Reference: Town & Country Planning Act 1990 – R/151/18/HH

Reference: Retrospective Planning Application – 18 Dingley Road – R/151/18/HH

New Raised path - New fencing

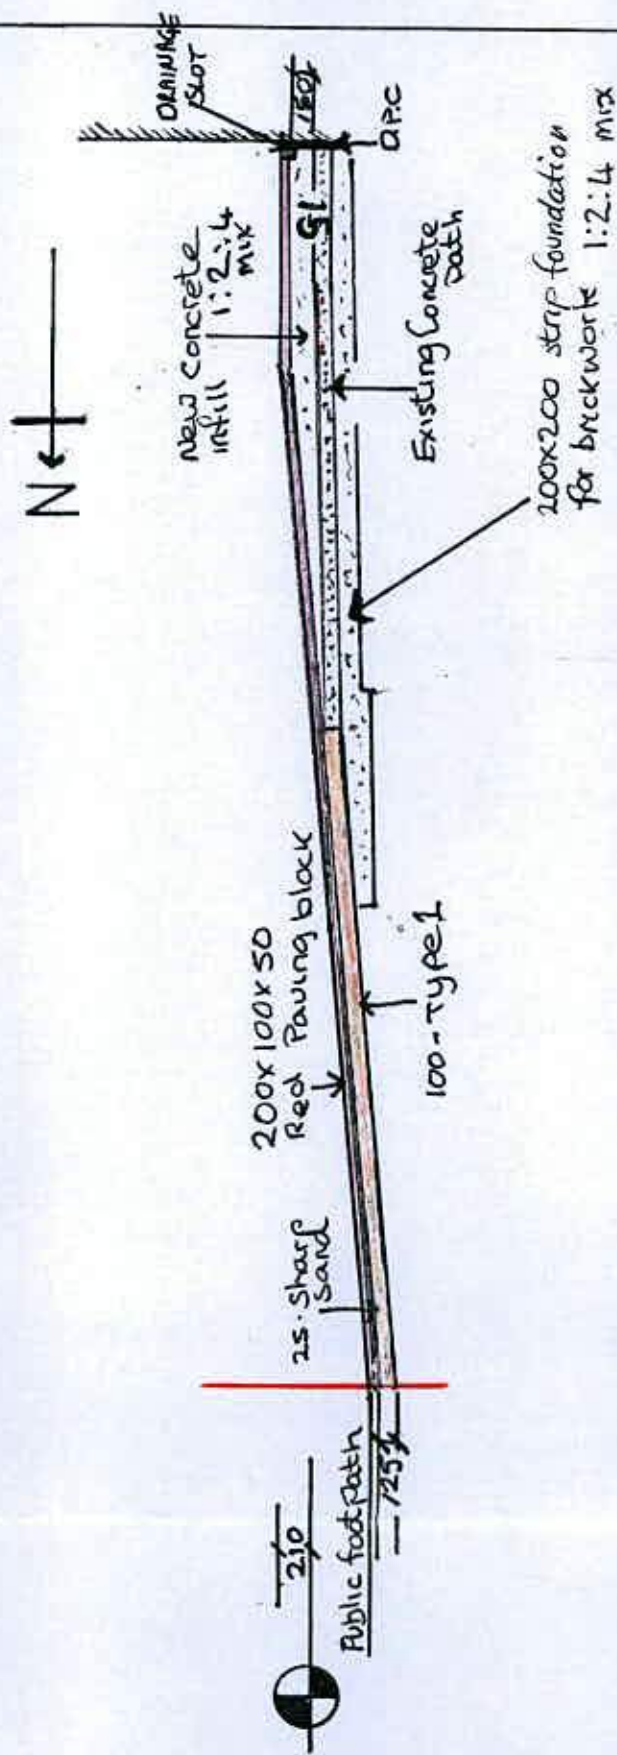
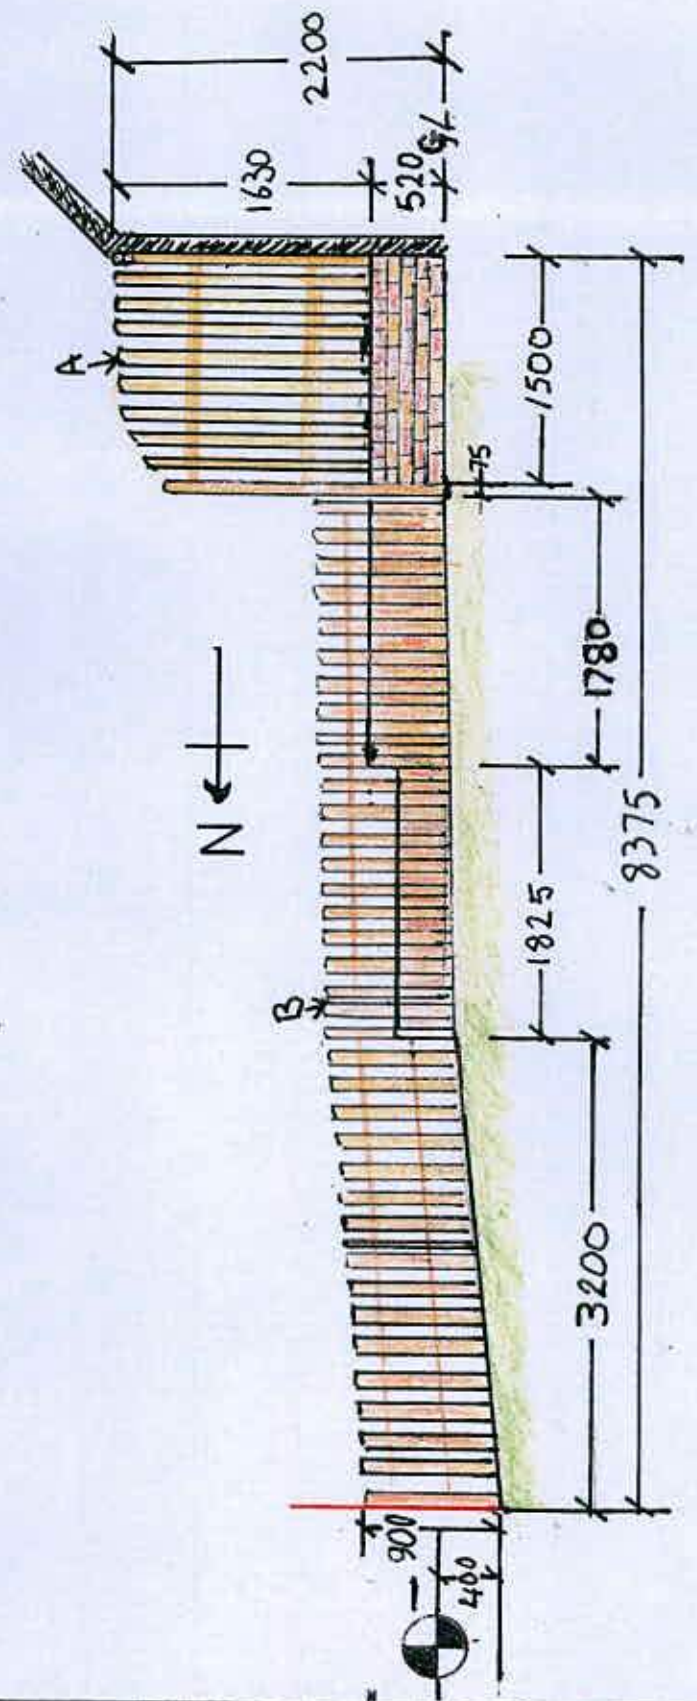
Whilst I can acknowledge the necessity for a ramp to number 18 in order to facilitate ease of entry and egress for the owner, I cannot acknowledge that the guide wall needs to be quite so obtrusive.

Having read the comments on the plans in regard to the fencing, I fail to see that the stockade type fence between 16 and 18 would in any way reduce any supposed boiler fumes.

Extending the fence to the pavement in order to stop the occupants of number 16 using the footpath. If in fact the occupants of 16 do indeed use the footpath, would not a neighbourly word suffice rather than a fence?

The comment regarding the fence between 18 and 20 is to hide the rubbish tip in number 20, what rubbish tip? Number 20 has a very attractive garden space in a sea of gravel and concrete.

The large fence which is already in situ between 16 and 18 and also the fence between 18 and 20 are both clearly in breach of the above and the reasons for the erections as stated on the plans are questionable, as is extending the fence between 16 and 18 to the pavement.
